SPR EA1N and EA2 PROJECTS

SASES DEADLINE 2 – COMMENTS ON EXQ 1 RESPONSES - 1.9 LAND USE

Interested Party: SASES

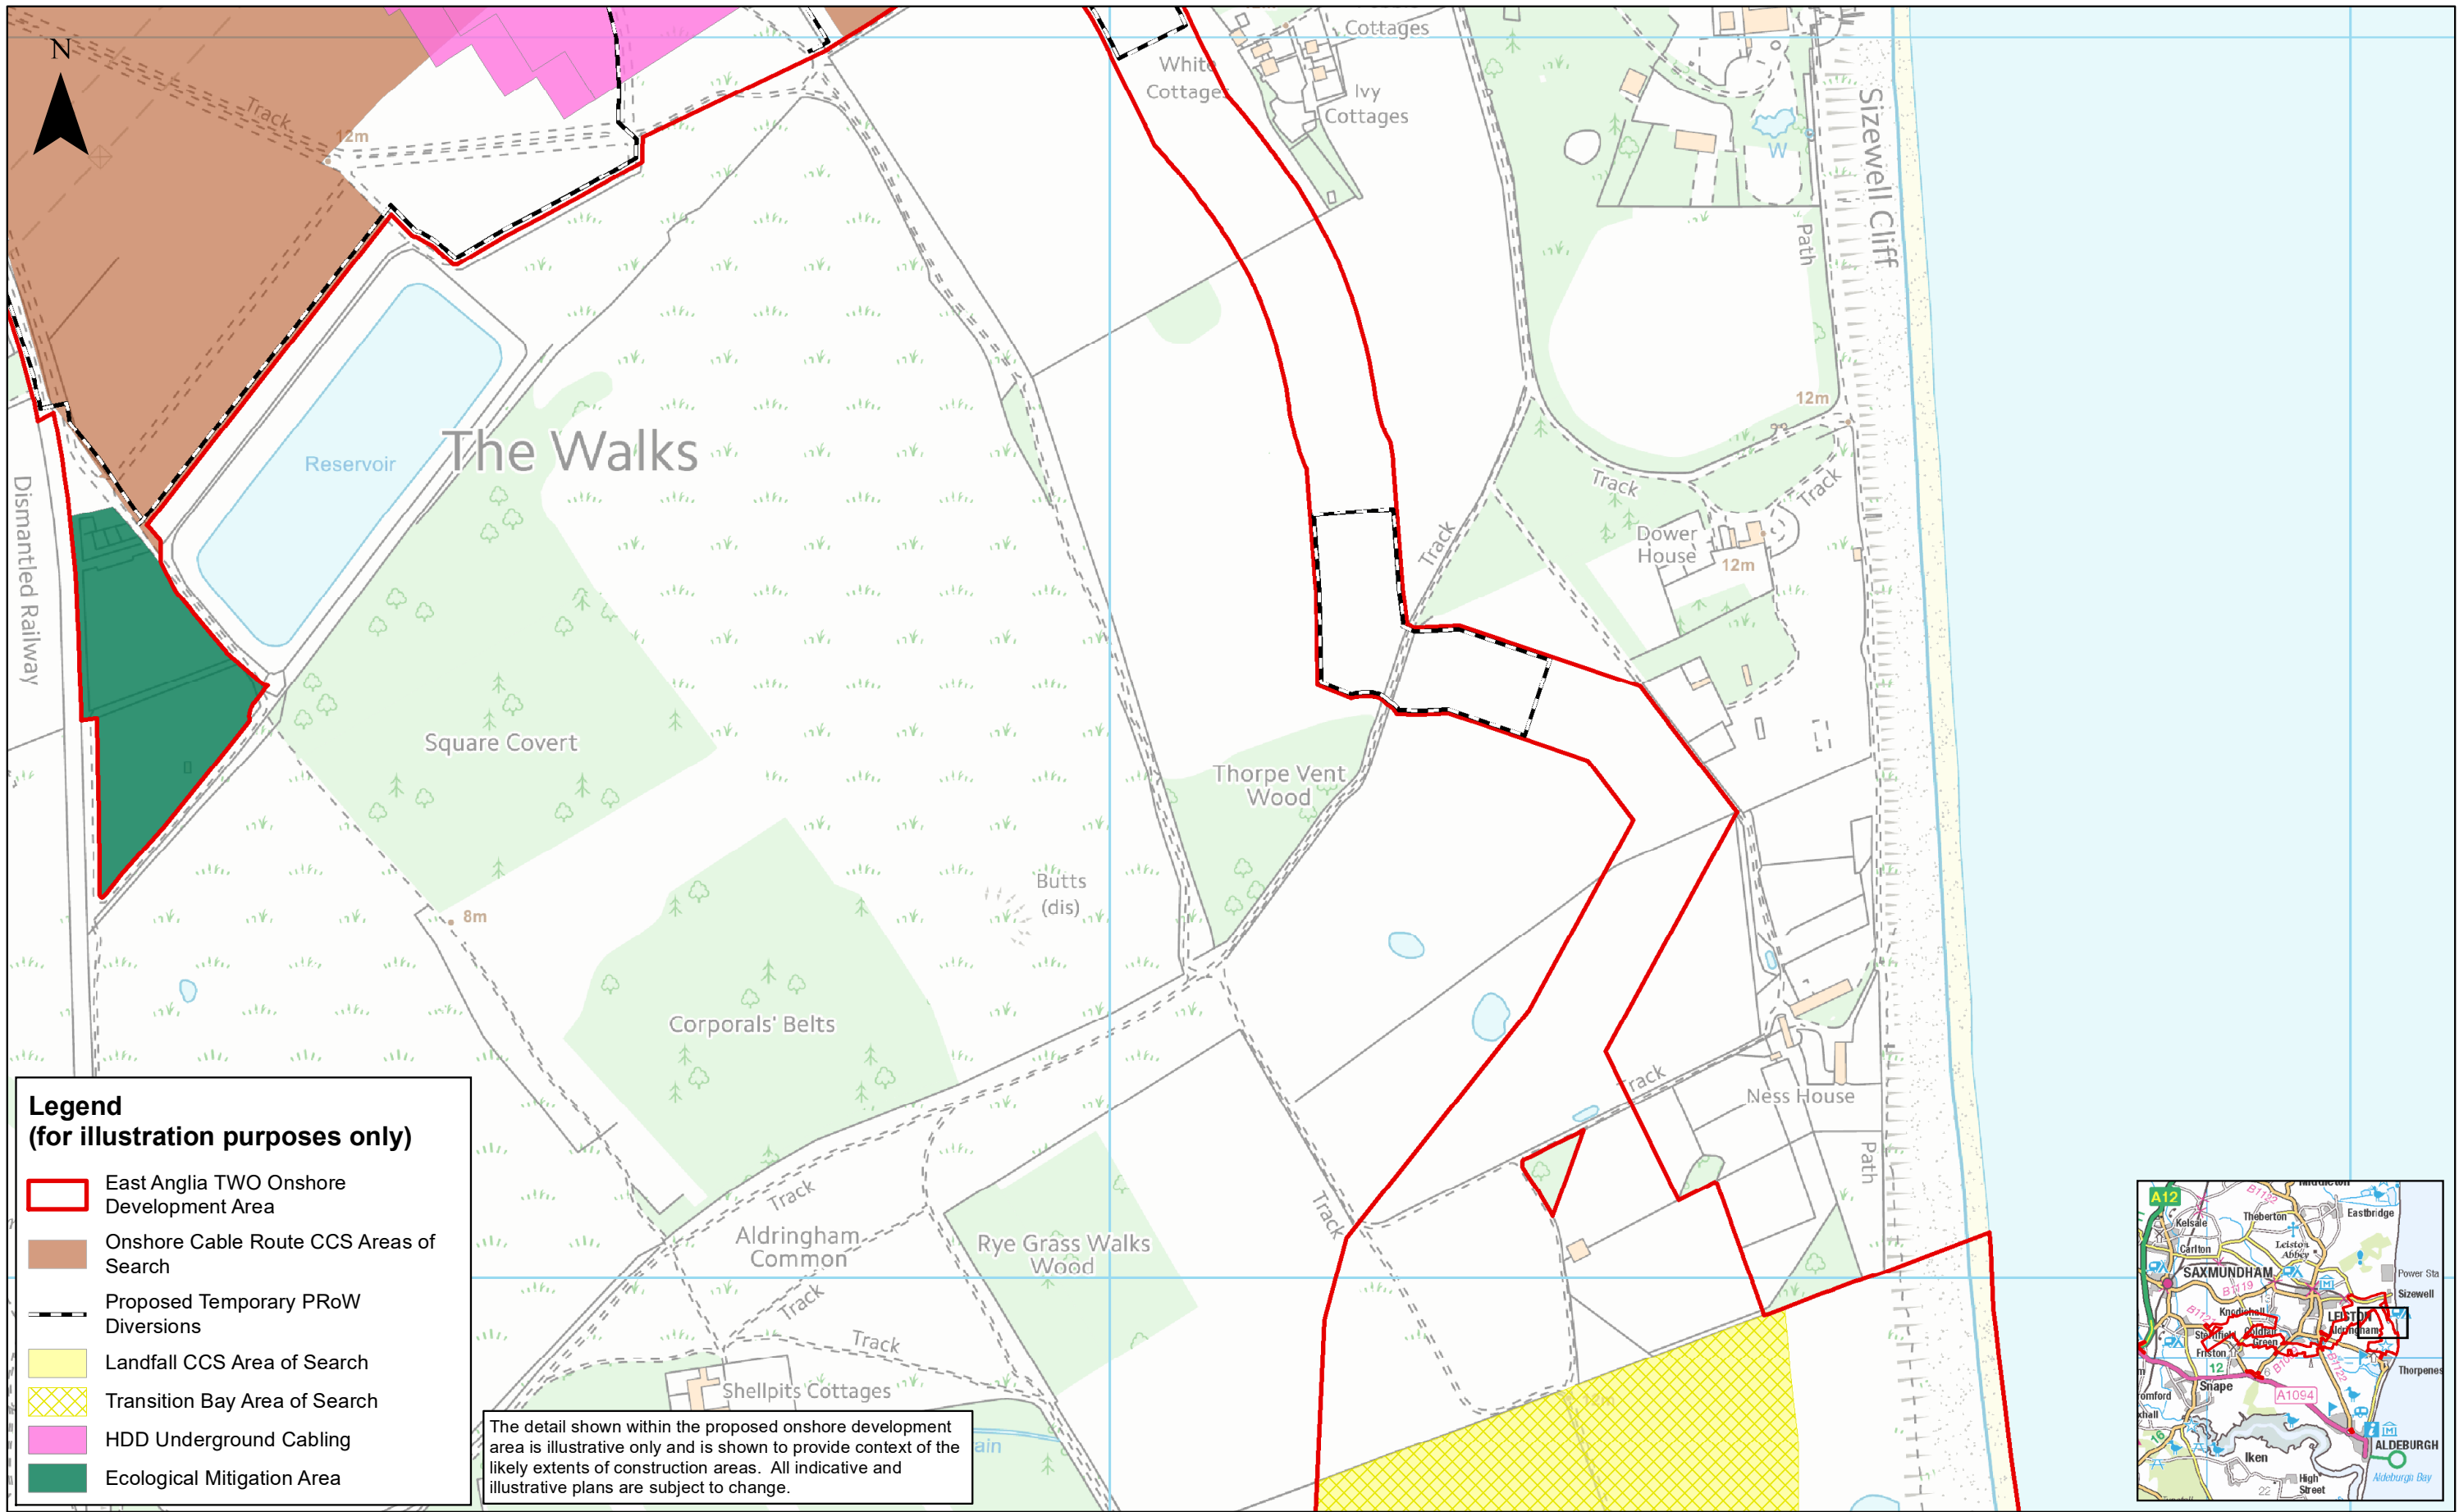
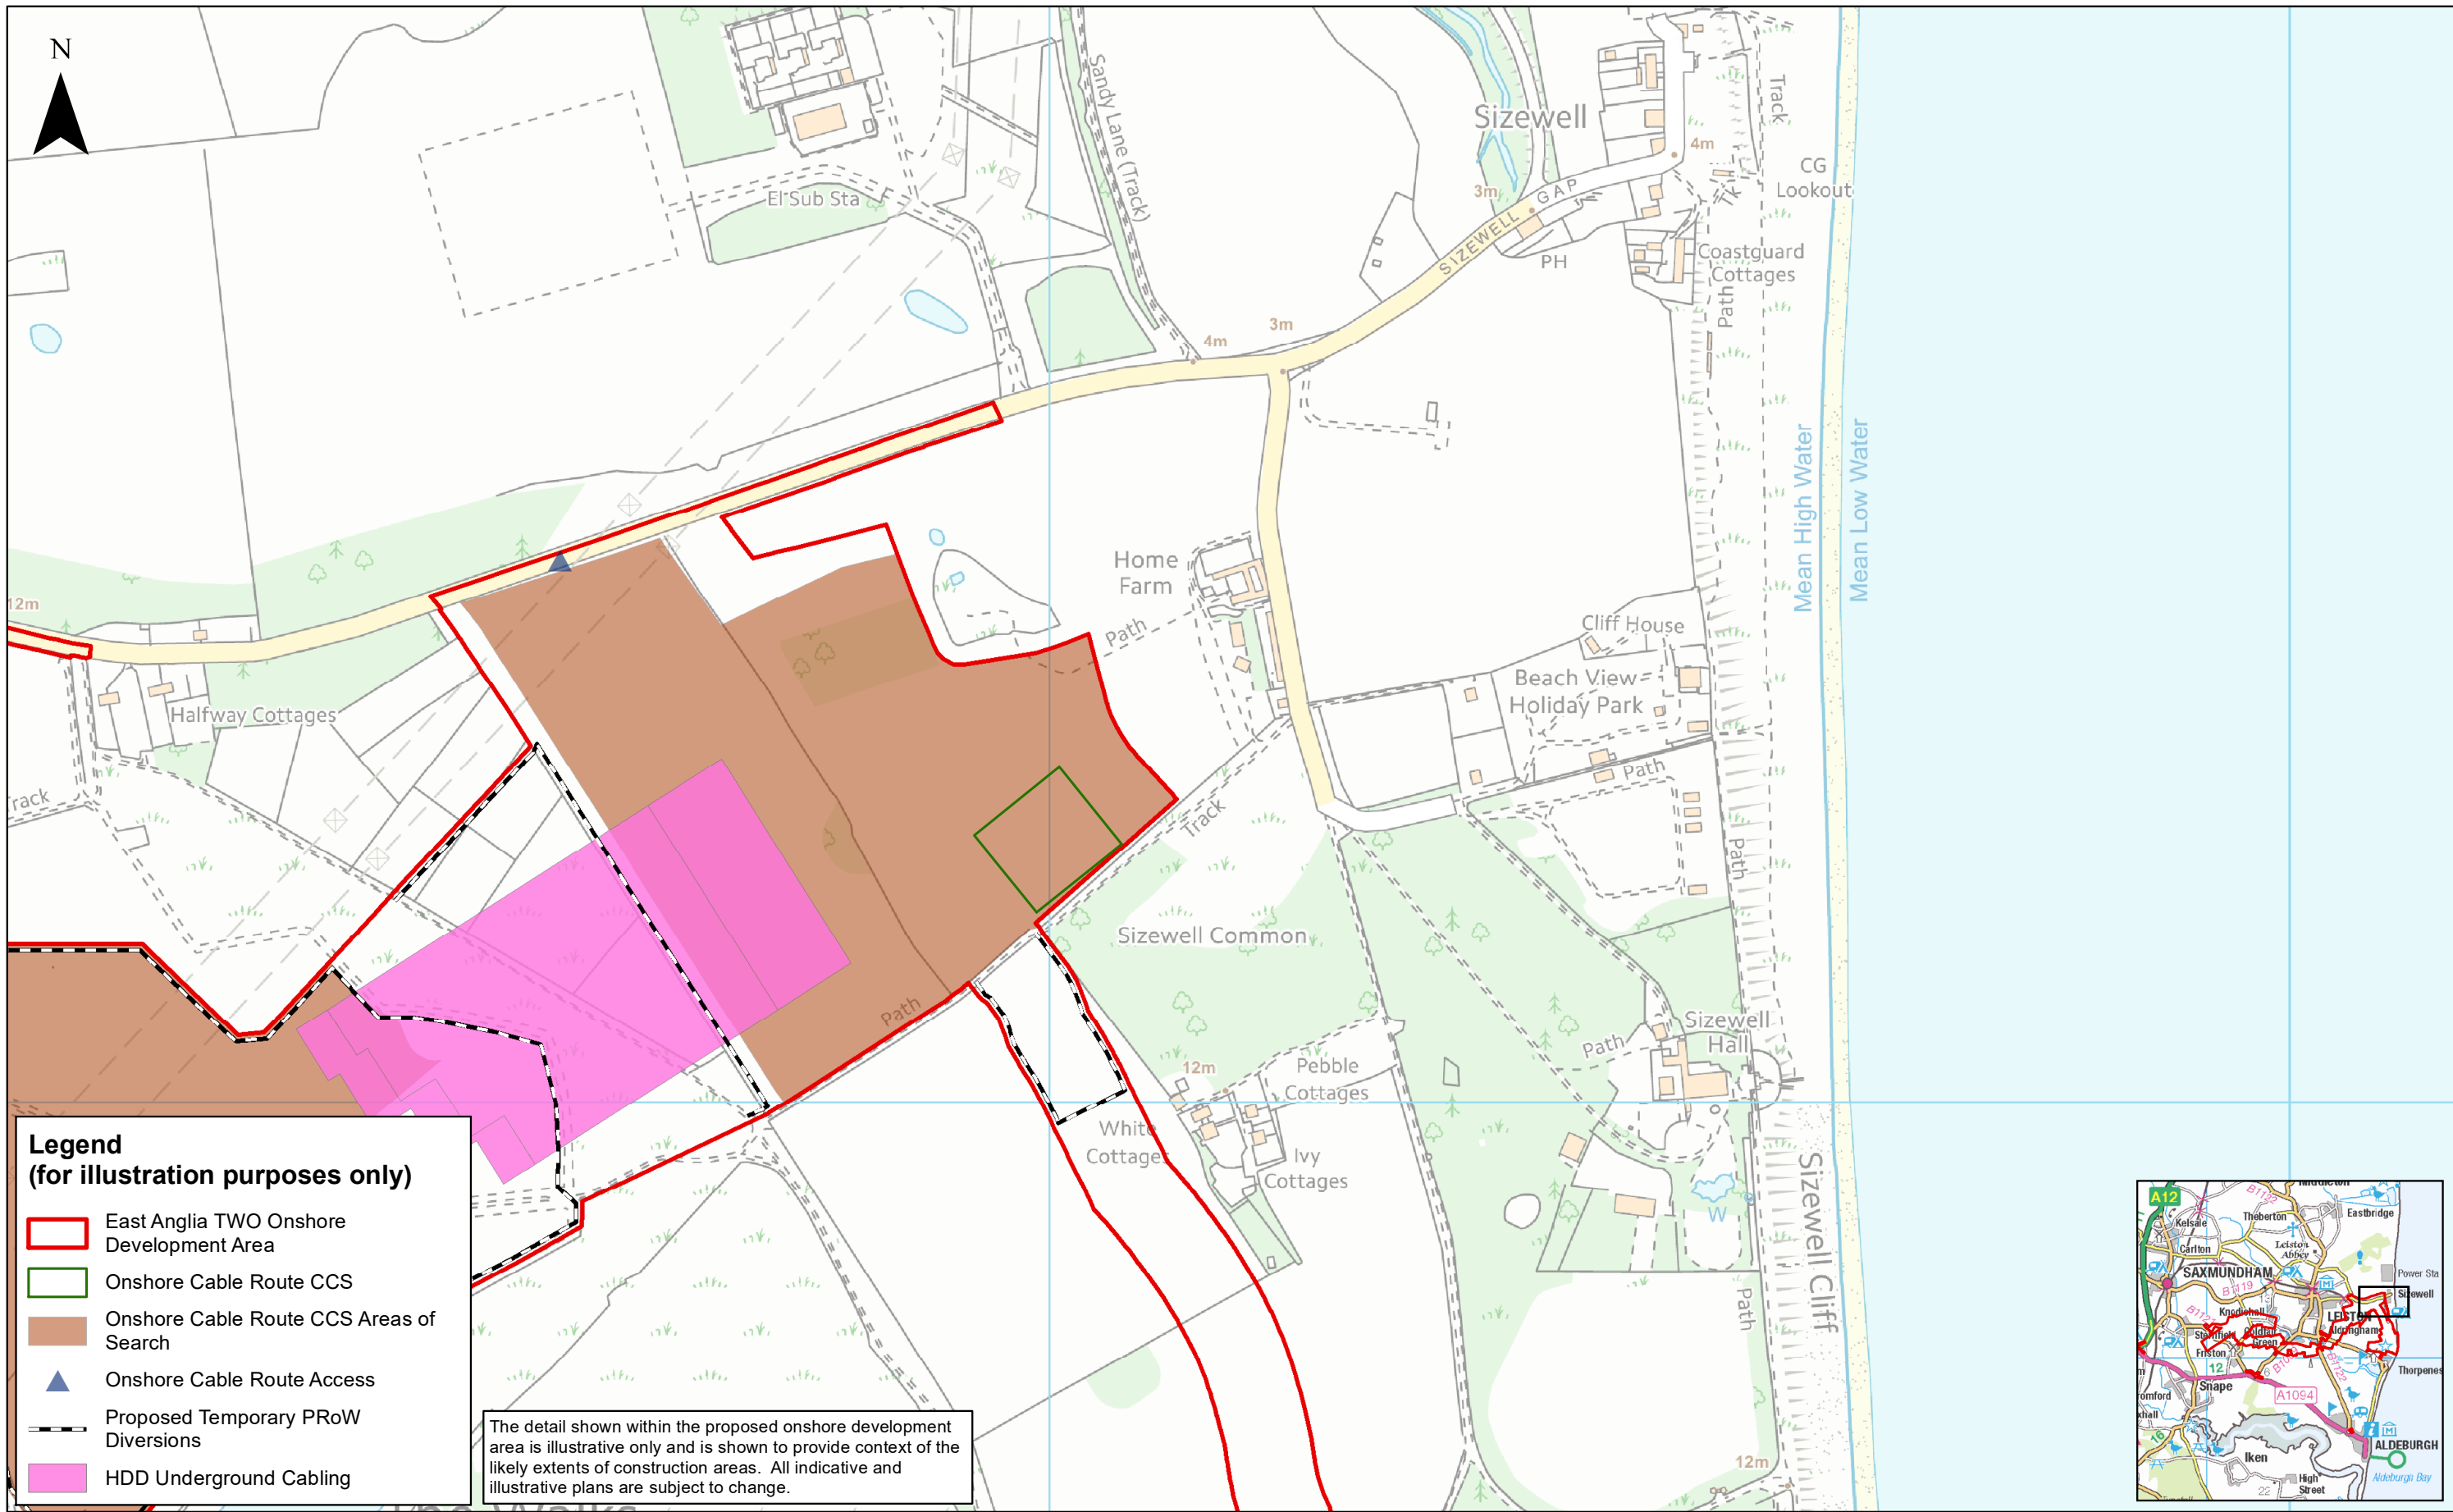
<p>1.9.21 PRoW Strategy</p>	<p>Explain what measures you will take to avoid nuisance and ensure the safety, amenity and quiet enjoyment by those using them in the vicinity of the construction works, with particular reference to the Suffolk Coastal Path</p>	<p>The Applicant has answered this question mainly in relation to the landfall location at Thorpeness.</p>	<p>SASES asks for an explanation of what measures will be taken with regard to the PRoW network on the substation site at Friston during the construction period. Specifically what footpaths will be open and available for use and how safety, amenity and quiet enjoyment can be maintained.</p>
